RE: THOMAS STREET CAR PARK SITE CHATSWOOD MP09_0066 MODIFICATION 14

I refer to your advice regarding proposed Modification 14 to MP09_0066 for the mixed use development on the Thomas Street Car Park Site in Chatswood by Karimbla Construction Services (NSW) Pty Ltd.

A-0121

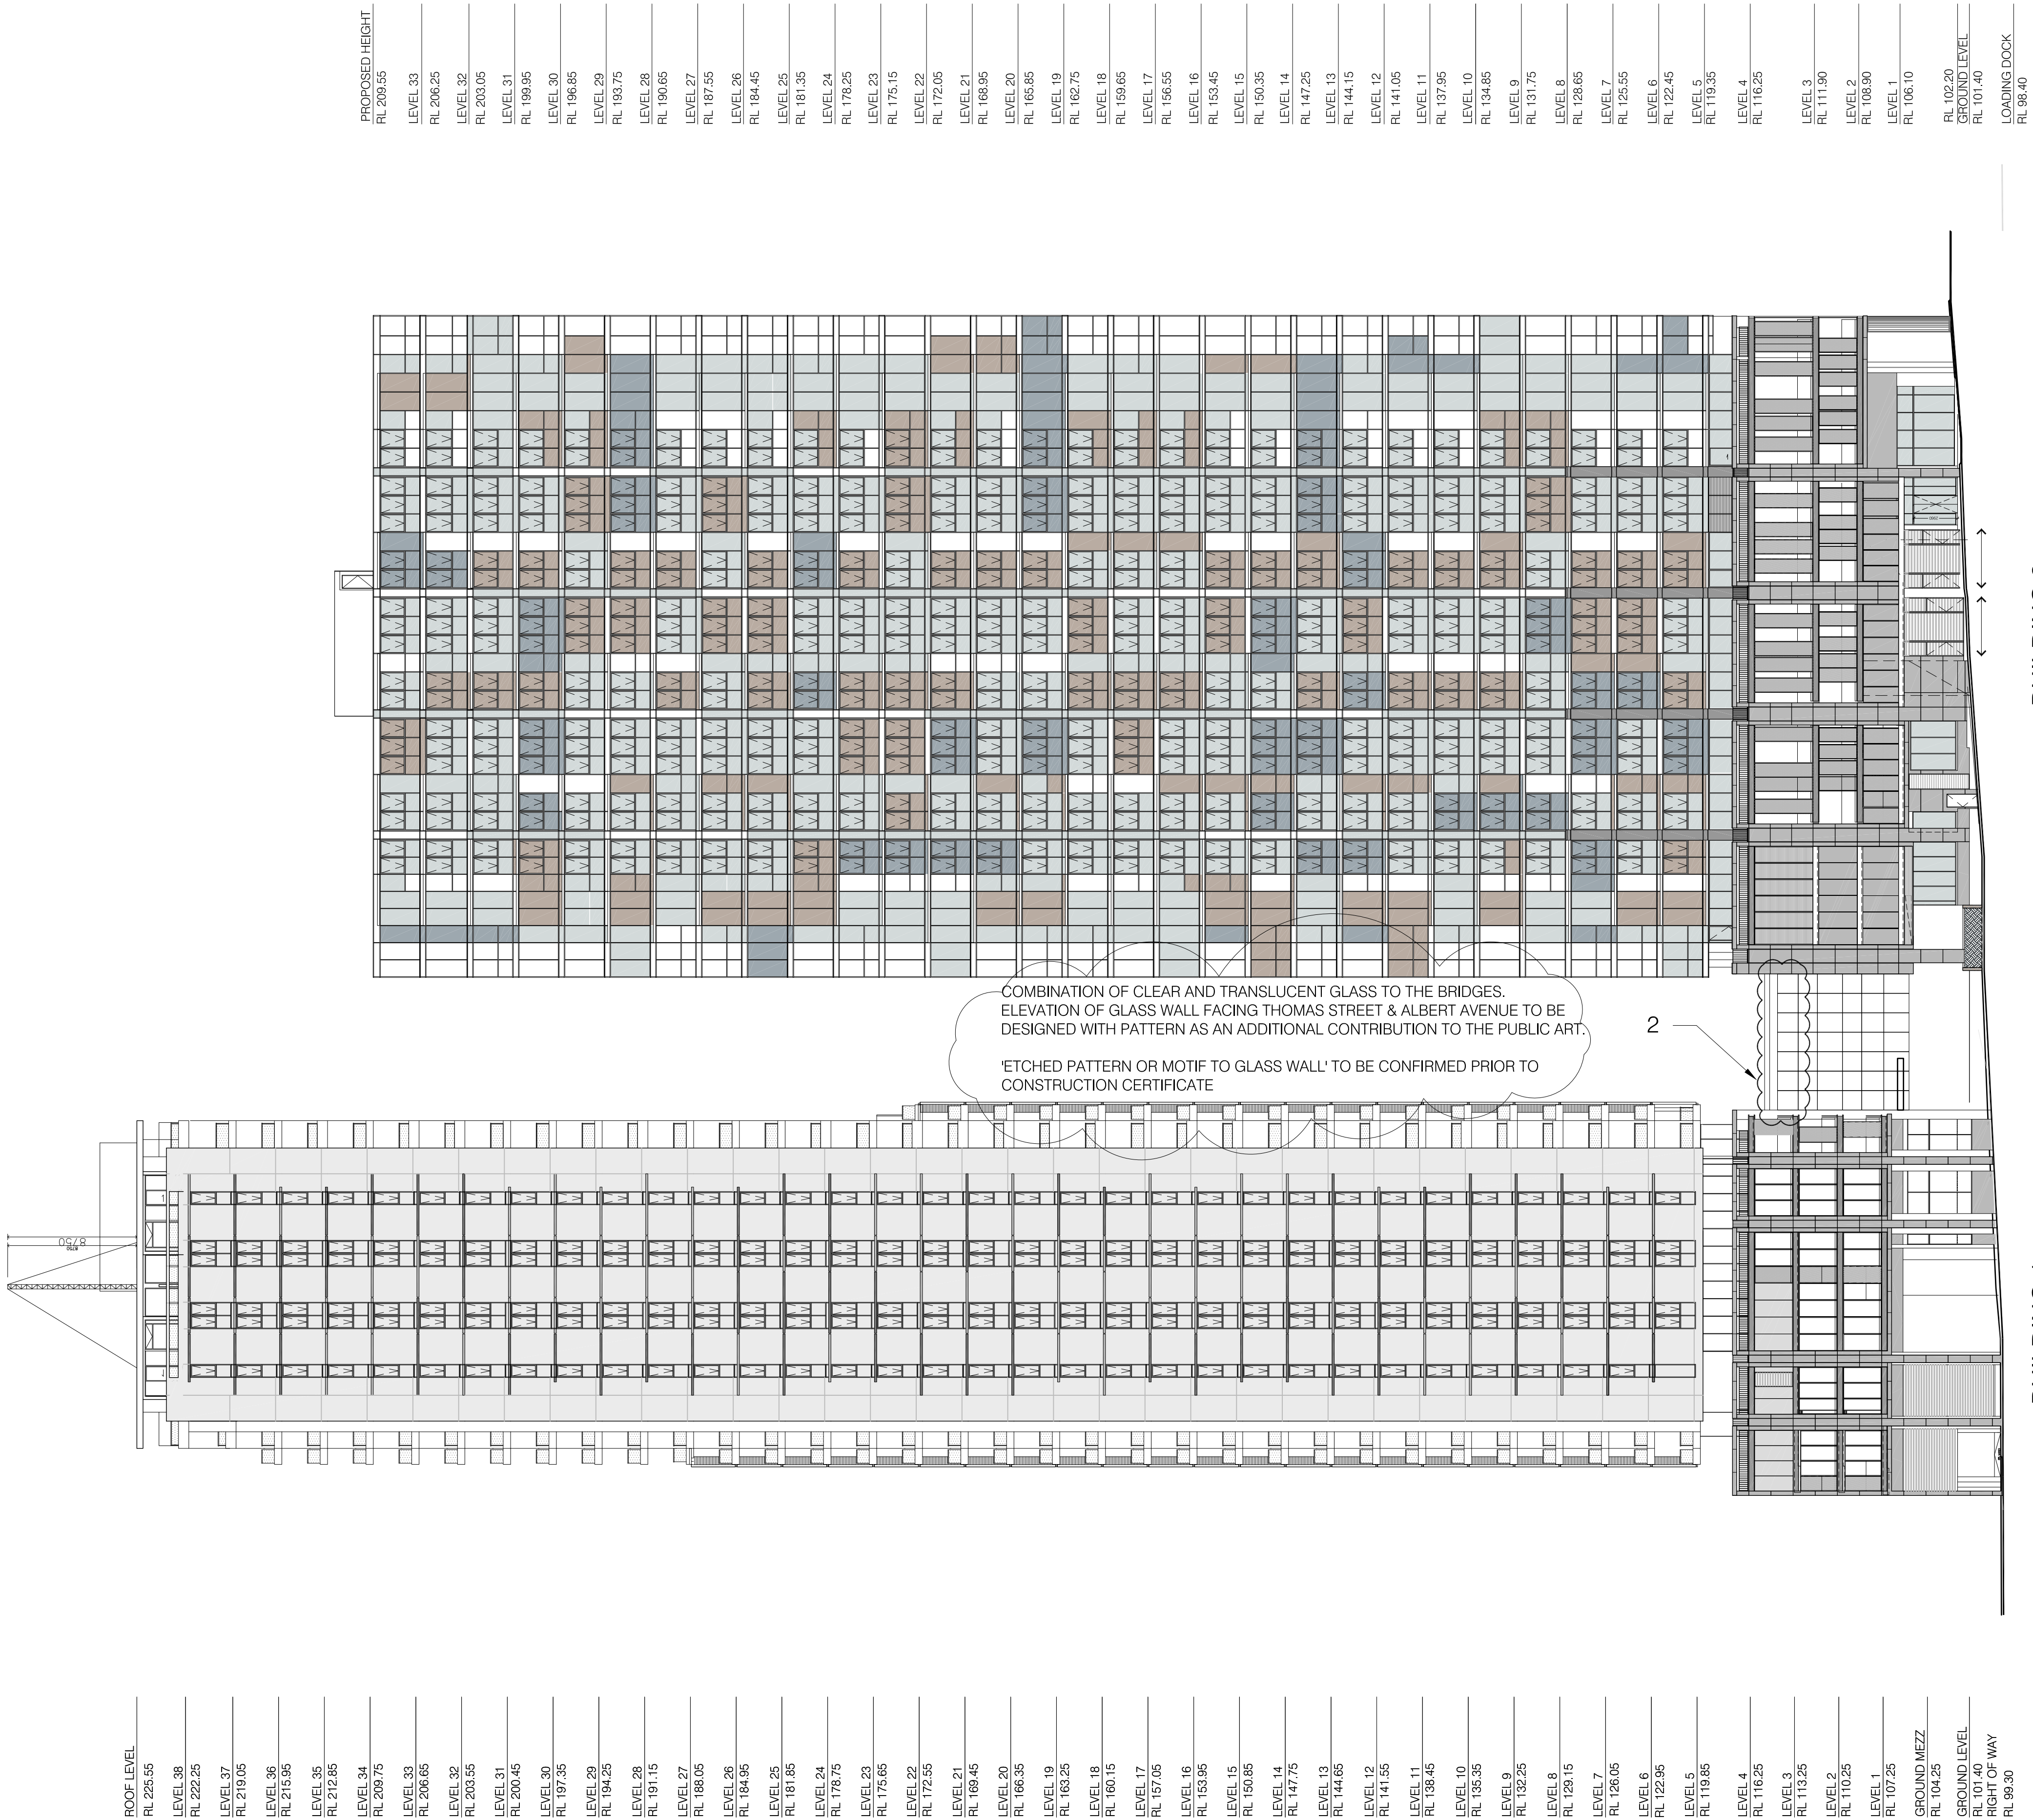
The second matter in the modification proposes to enclose the bridge connections between the two buildings at levels 1, 2 and 3 to enable weather protected access between the building on those levels for vehicles and pedestrians. The enclosing of the bridges is proposed by provision of a light weight roof over each bridge and provision of glazed walls. It is not indicated whether the glazed walls will be translucent or clear glazing.

Council considers that the glazing should provide an etched pattern or motif in the elevation of the glass walls facing Thomas Street and the plaza and Albert Avenue. This should be required to be provided as an additional detailed design plan. The objective is to maintain the architectural presentation of the facades as contemplated in the consent, as well as provide an additional contribution to the public art on the site and the design that may complement the theme of the sculpture proposed on the Thomas Street frontage.
